# **OXFORDSHIRE COUNTY COUNCIL'S RESPONSE TO CONSULTATION ON THE FOLLOWING DEVELOPMENT PROPOSAL**

**Application no:** 15/00760/F-4

**Proposal:** Development of a new Local Centre comprising a Convenience Store (use class A1), Retail Units (flexible use class A1/A3/A5), Pub (use class A4), Community Hall (use class D1), Nursery (use class D1), Commercial Units (flexible use class A2/B1/D1) with associated Access, Servicing, Landscaping and Parking with a total GEA of 3,617 sqm

## **Transport**

Rendered Landscape Masterplan

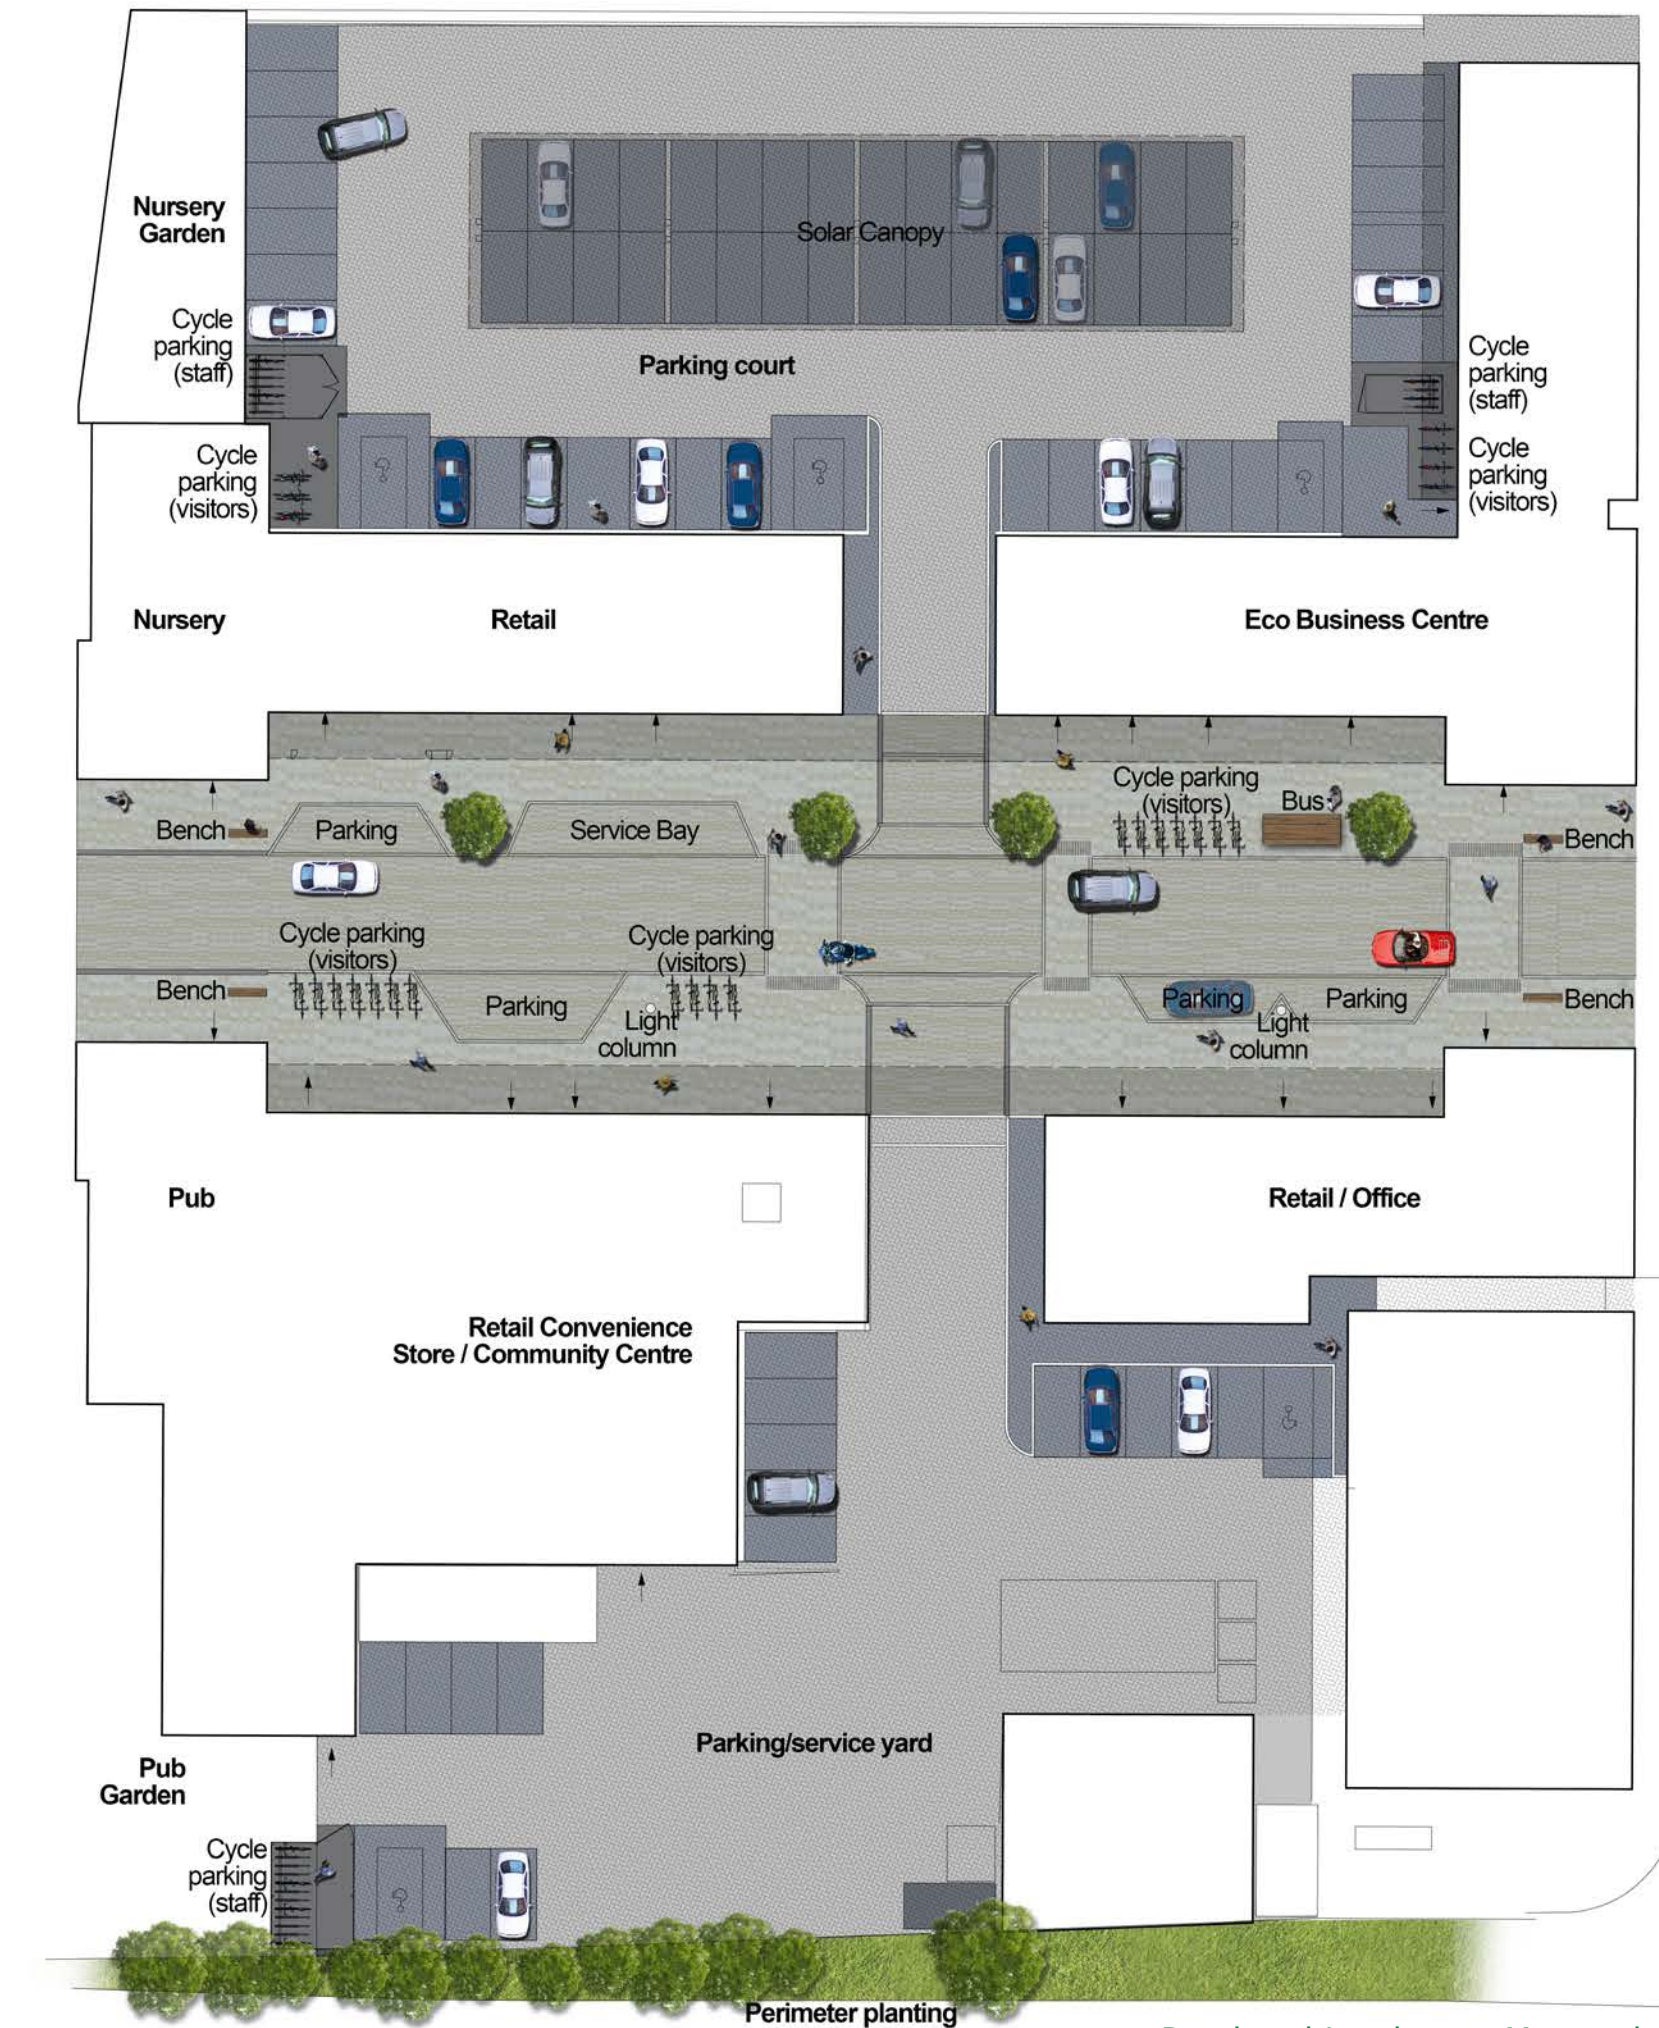
The latest amendments reflect our previous comments and concerns in respect of the geometric layout, however, we are concerned that the Landscape Masterplan (ref: 5250-UA005241-02) has not been superseded as it also states on the plan that it is “Planning – not to be used for construction”. Given our previous concerns in respect of the adoptability of the proposed highway within the scheme based on this plan i.e. which is unacceptable we would like to see a condition that agrees the final surface treatment of the proposed highway that can be adopted by the County Council, particularly as a section 38 agreement already exists – amendments to the agreement will be necessary.

To conclude on the above the County Council considers the overall layout of the scheme to be acceptable, however, proposed materials are another issue affecting adoptability of the proposed development. In light of this element of the design namely the Landscape Masterplan need consideration and amending in order for the layout to be designed to an adoptable standard, although we understand a condition agreeing the final surface treatment can overcome this.

- Final surface treatment to be agreed;
- The proposed highway design would need to be the subject of a revision to the S38 agreement, which would require further technical audit.

Prior to the commencement of the development hereby approved, full specification details of the spine road through the development including construction, surfacing, layout, drainage and road markings, shall be submitted to and approved in writing by the Local Planning Authority. Thereafter and prior to the first occupation of any of the buildings in the local centre the road/footways etc. shall be constructed in accordance with the approved details.
